PUBLIC PLANNING SUBMISSION: AMENDED DEVELOPMENT OBJECTION

Application: State Significant Development – 138 Maroubra Road (SSD-81426710)

Perspective: Surrounding Community Members & Adjoining Residential Neighbors

POLICE STATION SITE
SUBJECT SITE

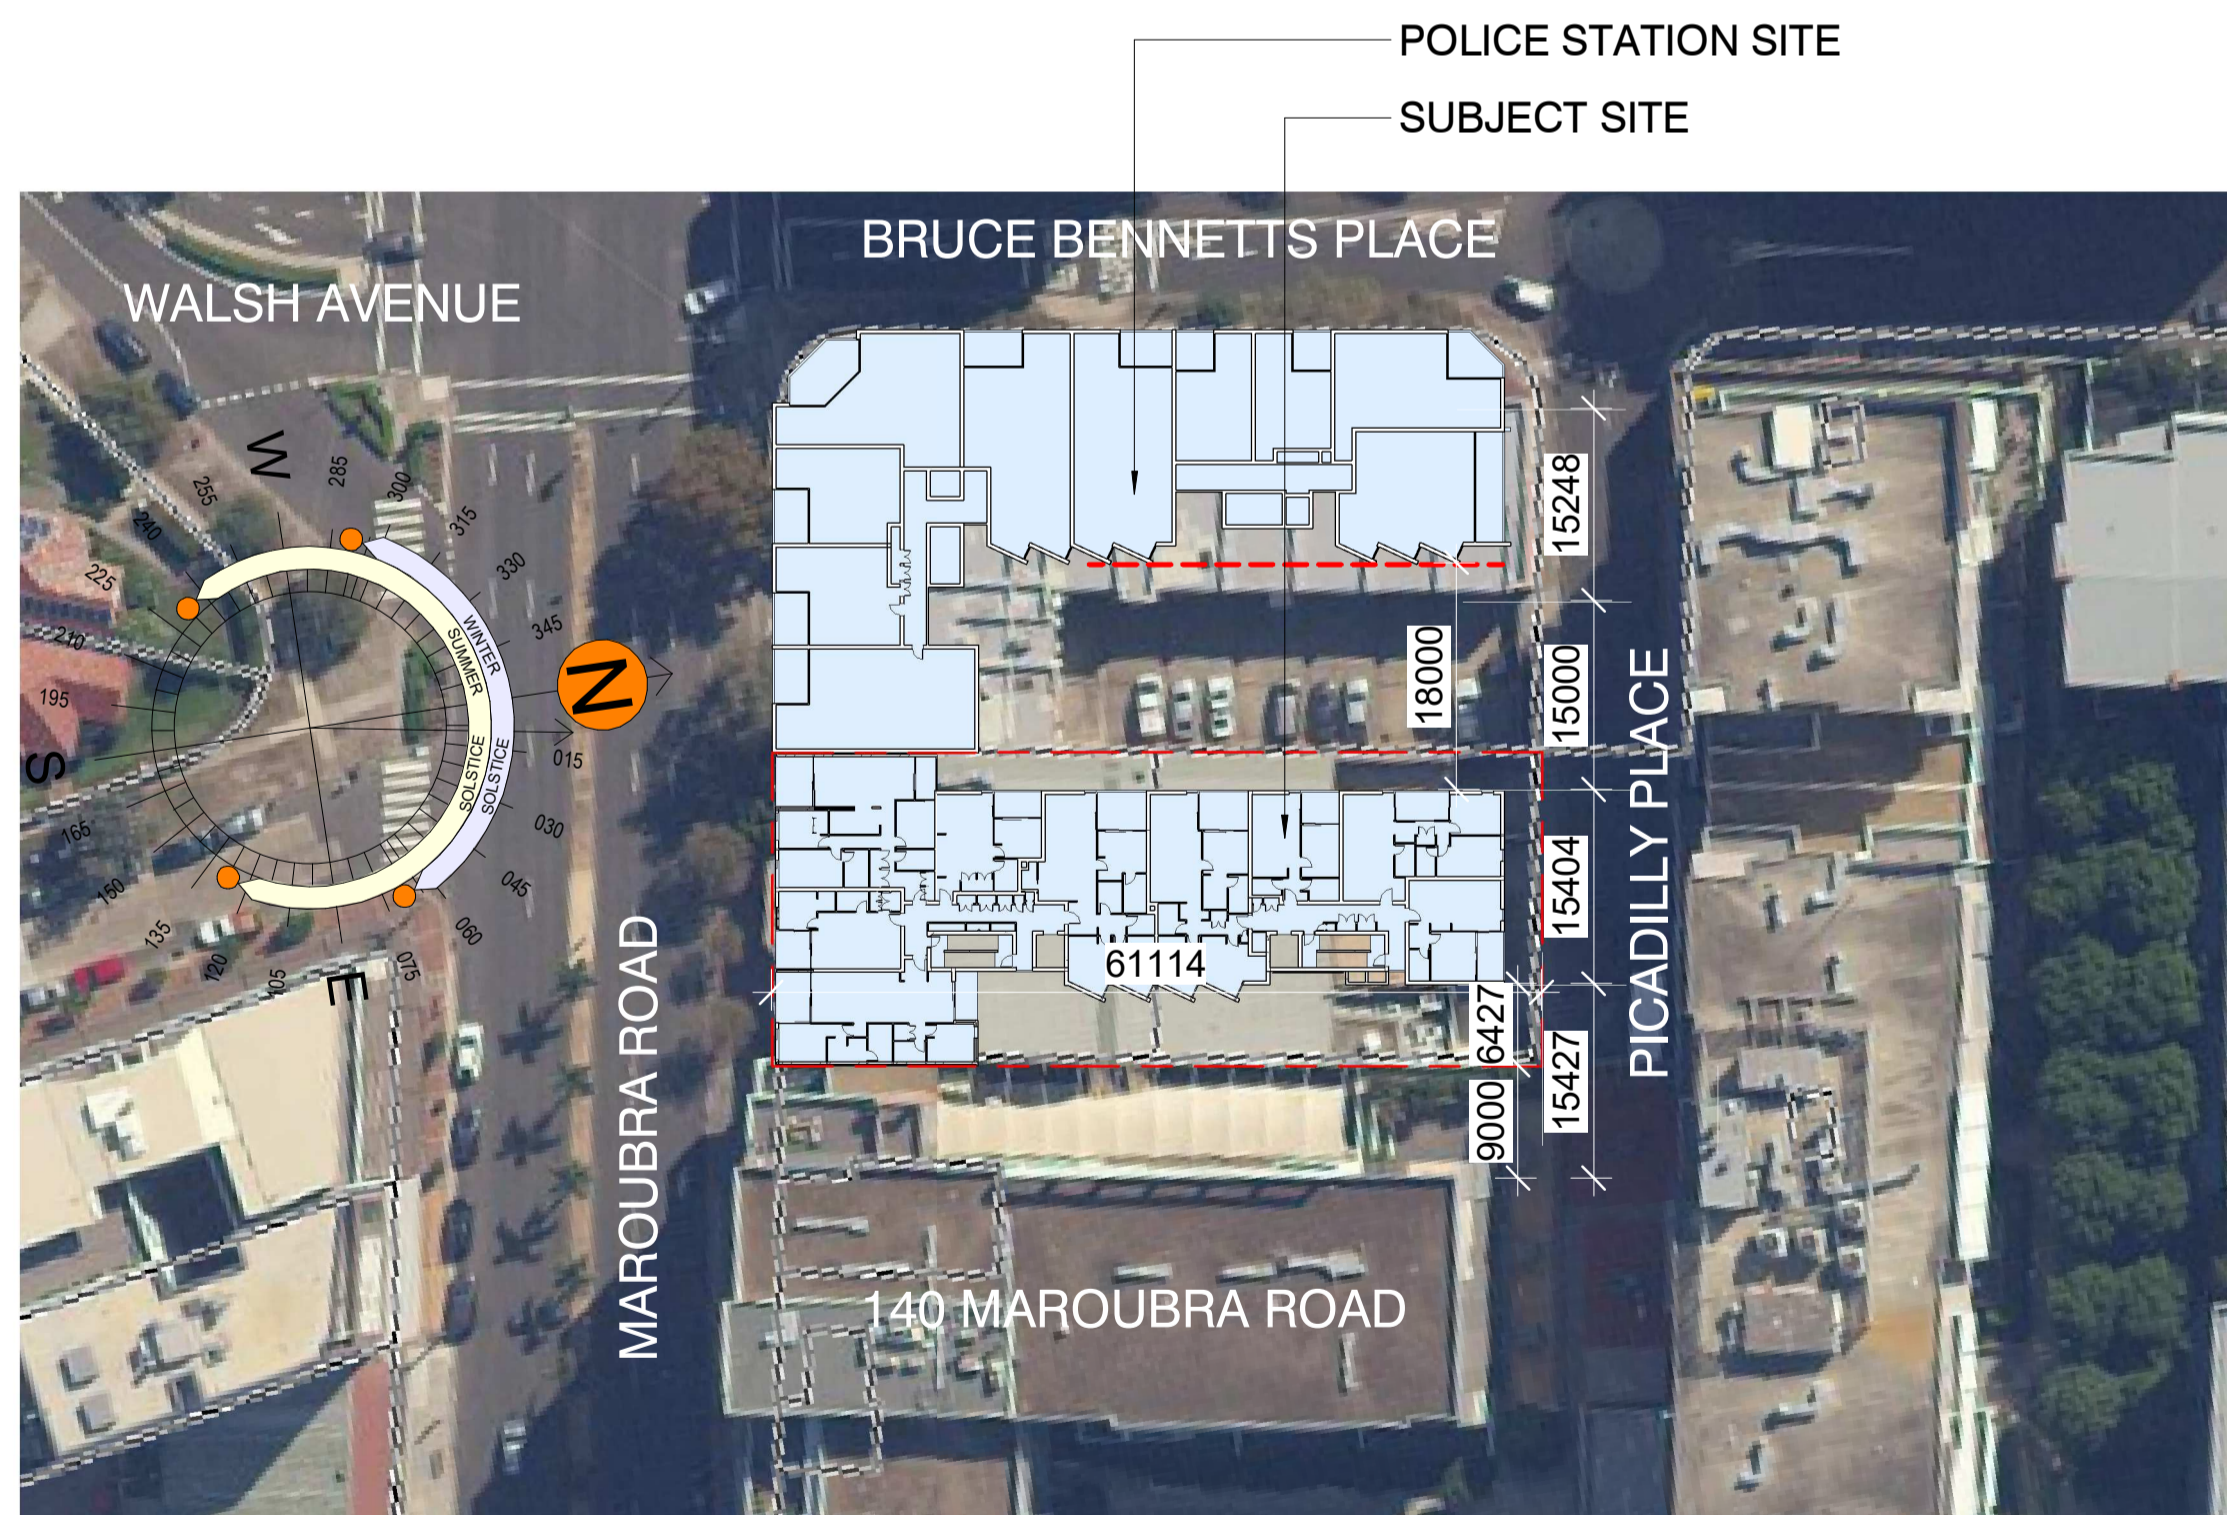
The Land and Environment Court previously determined that this specific site is physically incapable of absorbing a high-density, multi-storey footprint without first consolidating neighboring land—explicitly noting the developer's failure to acquire the adjacent Police Station plot.

Instead of restructuring the proposal to fit within the physical limits of the single, un-merged block, the applicant has simply expanded vertically to a 10-storey layout. This aggressive overdevelopment overloads the block, crowds out surrounding low-to-mid-rise residential properties, and establishes a dangerous precedent that completely disregards orderly community planning and local neighborhood character.

DRAWN BY	SCALE	SHEET SIZE	PRINT DATE
Author	1:100	A1	18/09/2025
DESCRIPTION			REVISION
WEST ELEVATION			5:15:36 PM
PROJECT No	DRAWING No	REVISION	
21_435	DA2.203	N

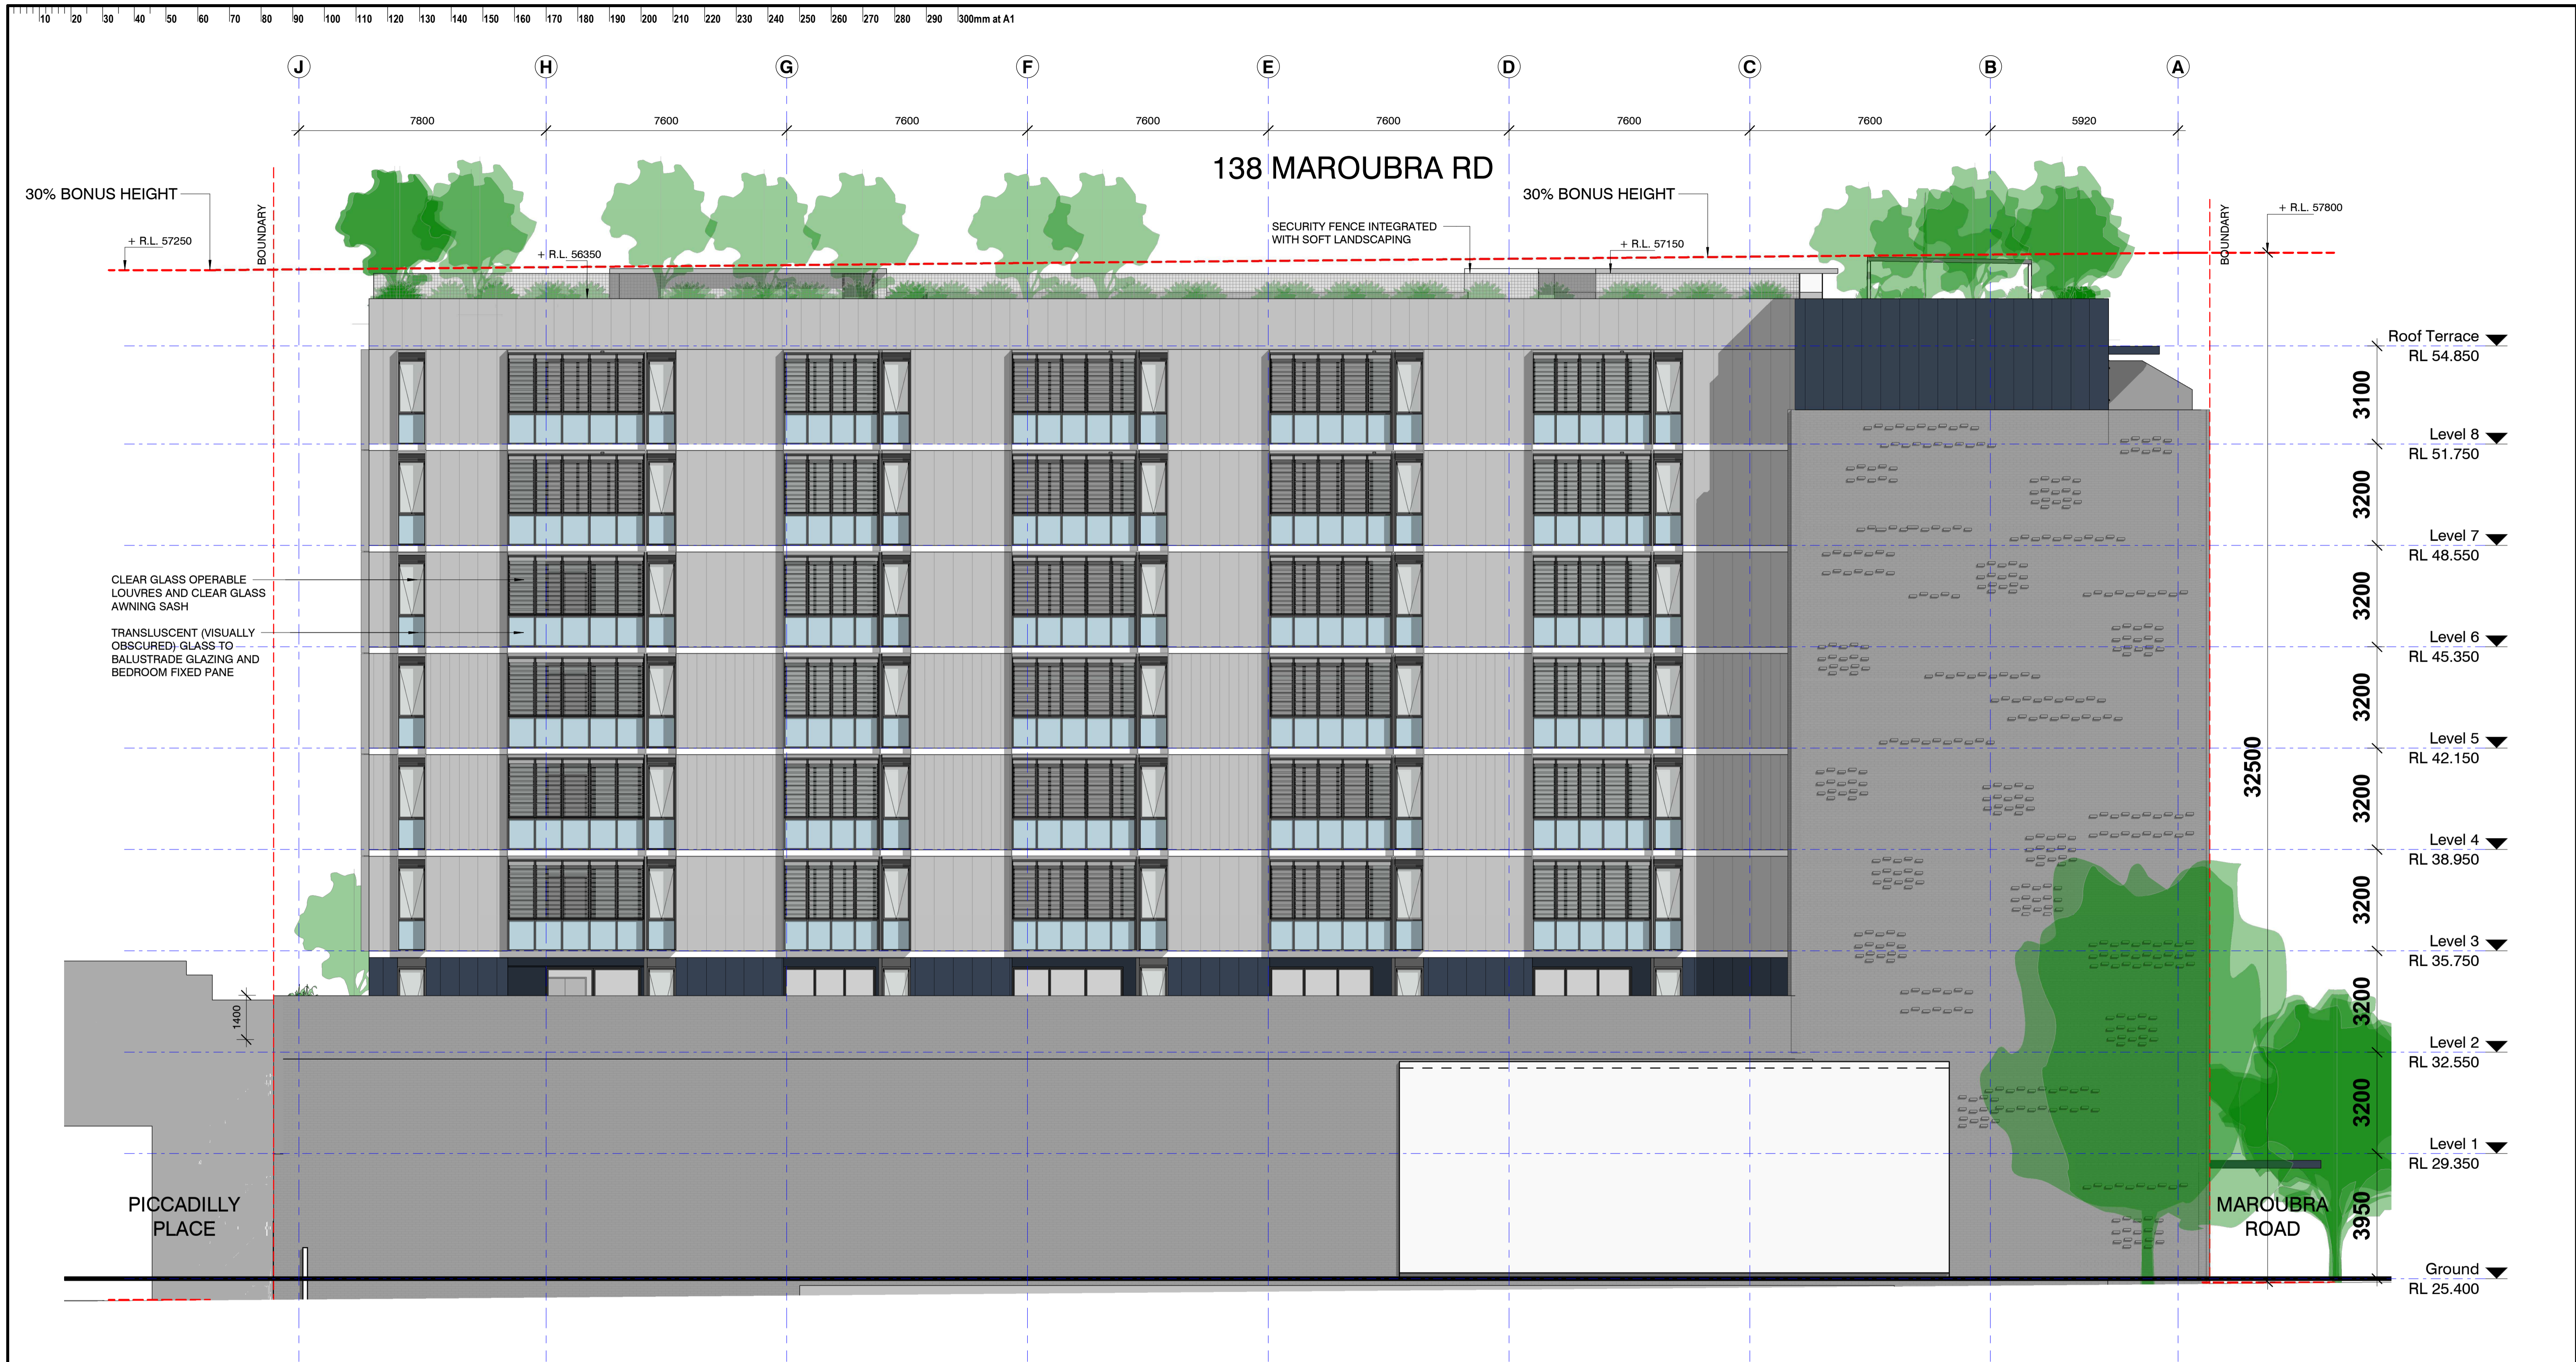
Boundary Encroachment and High-Wall Visual Oppression of Surrounding Living Spaces

The applicant's Submissions Report dismisses the loss of open western and southern outlooks for adjacent neighbors, claiming it is an acceptable consequence of urban development. This approach rejects the core view-sharing and residential privacy principles enforced by the Land and Environment Court.

By pushing a continuous 32.5-meter raw vertical concrete face right up to the shared boundary line, the design forces permanent visual claustrophobia onto existing properties. Surrounding neighbors will be forced to look directly at a massive 10-storey concrete wall outside their windows, severely reducing natural cross-ventilation, destroying spatial openness, and directly harming local residential livability.
